No.	Natural England's Relevant Representation -Appendix A - Generic Issues	RAG status Rel and WR Rep	Consultation, actions, progression	RAG status D1	Consultation, actions, progression	RAG status D2	Consultation, actions, progression	RAG status D3	Consultation, actions, progression	RAG status D3
Appendix A - Generic Issues										
1	We have continued concerns that not all the risks related to the proposal have been fully considered which means that, following the precautionary principle, we are unable to exclude, beyond all reasonable scientific doubt, no Adverse Effect on Integrity of the Wash SPA or The Wash & North Norfolk Coast SAC.		NE has advised the Applicant (in writing through our DAS service on 13th Sept) that unless the further information is provided to help determine the scale of the impacts, we will not be able to advise further on the appropriateness of any mitigation and/or compensatory measures and our advice will be more precautionary.		Ongoing		Ongoing		Ongoing

No.	Natural England's Relevant Representation - Appendix B - Offshore Ornithology	RAG status Rel and WR Rep	Consultation, actions, progression	RAG status at D1	Consultation, actions, progression	RAG sta

**Plate A1- 3 Mitigation measures proposed for the Habitat Mitigation Area**

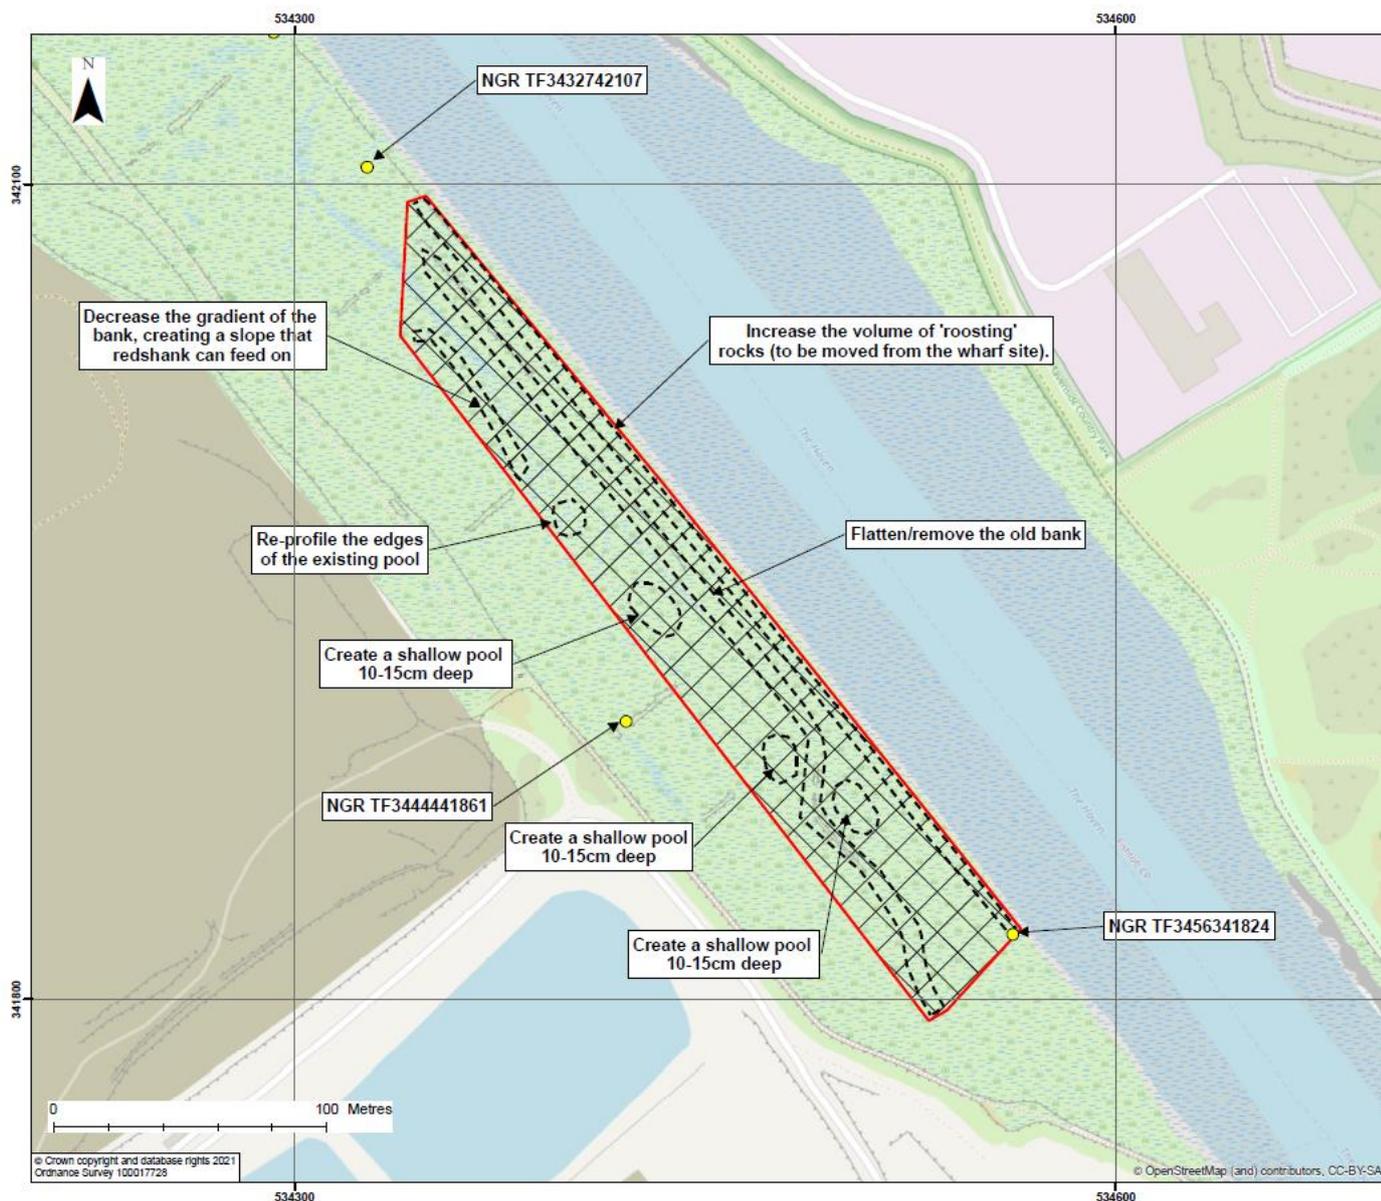
4	Under the Habitat Mitigation Works within the Habitat Mitigation Area it mentions 4 shallow pools (max 15cm deep) created in the existing saltmarsh. Natural England is concerned that without maintenance these will quickly silt up. Therefore, we query what ongoing management will be needed to maintain these pools? Is the intention for these pools/ scrapes to remain unvegetated? Area of the 4 pools? Will the scrapes/ pools result in direct loss of further saltmarsh vegetation? Has this been calculated? this information is vital to assess the benefits of the proposed new area.		Please see issue 22b in the Offshore Ornithology section.		Please see issue 22b in the Offshore Ornithology section.		Please see Appendix J1 at Deadline 3 for NE's advice on compensation.		Please see NE Appendix J2 at Deadline 5.
